Reigate & Banstead Outstanding Issues

Temporary NCR 21 Diversion

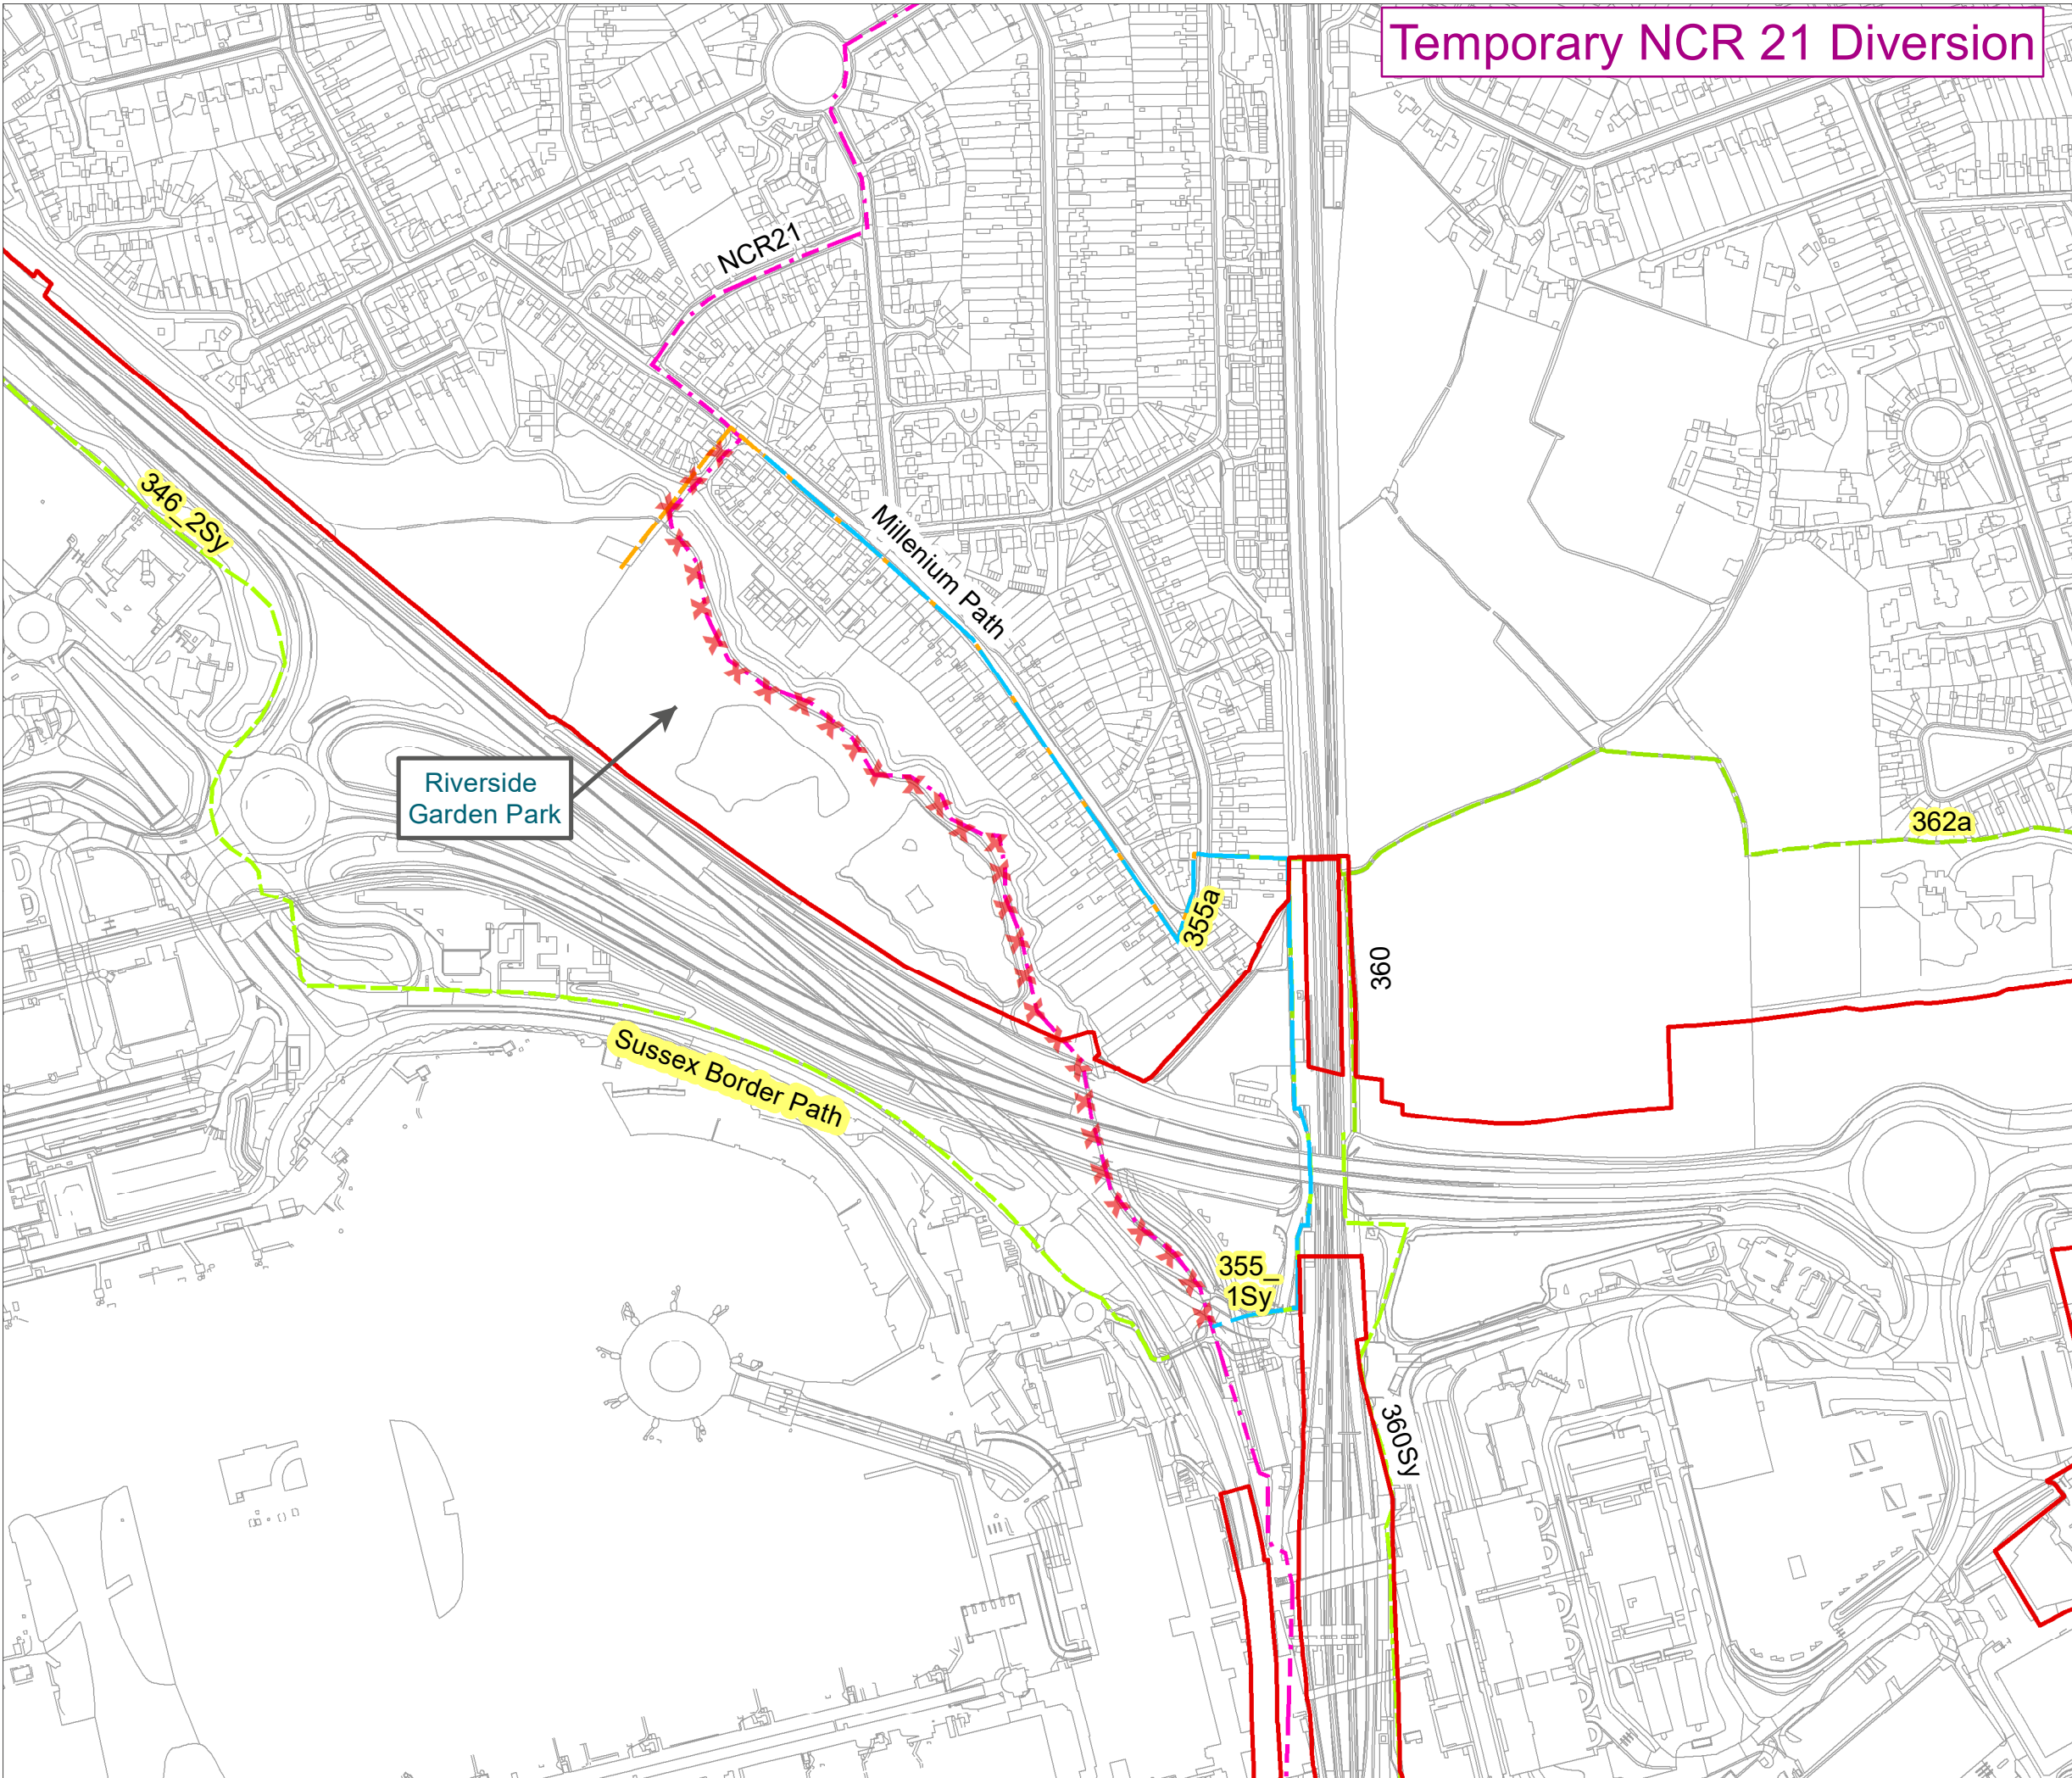
Land and Water	Nov-22 TWG Response	Suitability of location of cycle/pedestrian ramp linking A23 footpath and Riverside Gardens due to proximity of highways drainage Longevity of footpath closure 360/360sy 27 weeks, NCR21 - 12 weeks and resultant diversions - need to ensure north south footpaths are not all closed at same time in vicinity.
Land & Water	Nov-22 TWG Response	Clarity sought on proposed integration of Car Park B into Riverside Gardens and if acceptable to RBBC Green Spaces and Property Services. Have not seen Landscape Integration Plan
Land & Water	Apr-23 Raised in TWG	Lighting Strategy needs to be shared. Just became available with DCO publication.
Land & Water	Apr-23 Raised in TWG	Not clear if Car Park B is compensation for land take in Church Meadows and along Riverside Gardens and whether acceptable to RBBC.
Land & Water	Raised in TWG	
Land & Water	Emerging Statements of May-23 Common Ground	LTV.04.01 Baseline Environment no log of trees or vegetation appears to have been undertaken which is needed to assess the impacts and inform the mitigation
